Reference No:	<b>2025/62/91341/E</b>
Site Address:	4, South View, Savile Town, Dewsbury, WF12 9LE
Description:	Erection of second floor extension
Recommending Officer:	Jennifer Booth

**DECISION - REFUSE**

## **OFFICER REPORT**

**PROPOSED FRONT ELEVATION  
(South East)**

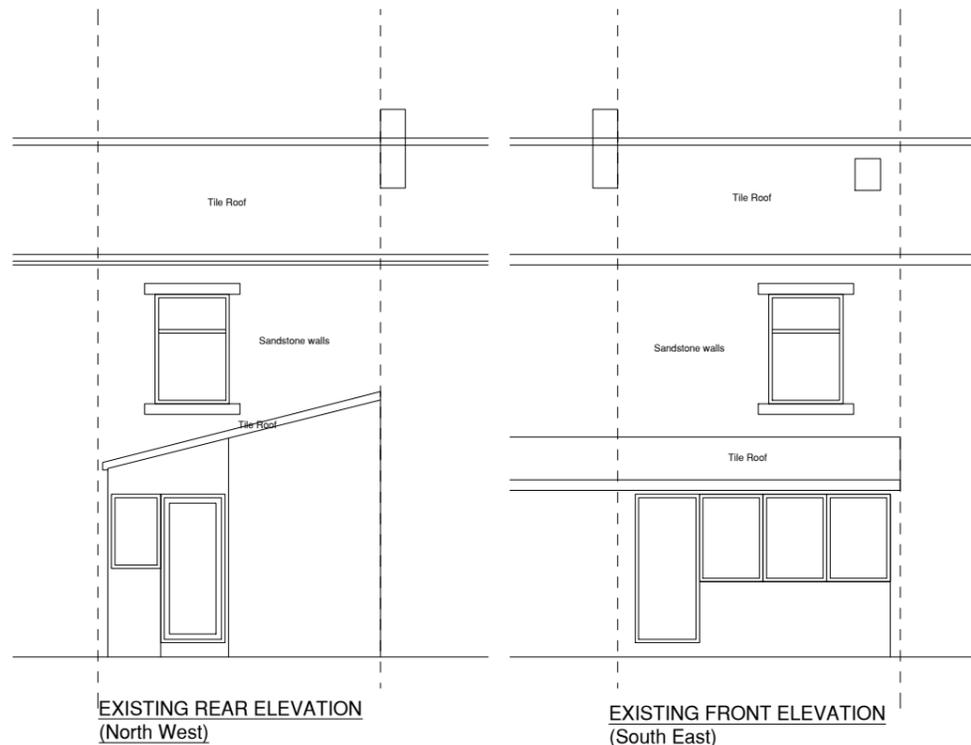
The eaves height would increase from 5.7m to 8.1 (2.4m increase) and the overall height would increase from 7.4m to 9.6m (2.2m increase). The pitched roof would be replicated and the windows would align with the windows below.

The current proposal seeks to raise the height of the host property by an additional 2.4 metres, which would result in a visually incongruous feature within the row. The House Extensions SPD, particularly Key Design Principles KDP1 and KDP2, places strong emphasis on preserving the character of both the host property and the wider area. This document carries considerable weight in the assessment of planning applications. There is no fallback

As such, the proposed upward extension, by virtue of its scale and prominence, would be out of keeping with the immediate building group and is considered unacceptable in terms of visual amenity.

The proposed raising of the roof, due to the design and height, would appear out of character with the host property and the overall character of the neighbouring dwellings within this row. Furthermore, the overall bulk and massing of the extension would not appear subservient to the original building and would therefore not promote good design. To permit the proposals would be detrimental in terms of visual amenity and contrary to policy LP24 of the Kirklees Local Plan, KDP1 & KDP2 of the House Extensions & Alterations SPD and advice within chapter 12 of the National Planning Policy Framework.
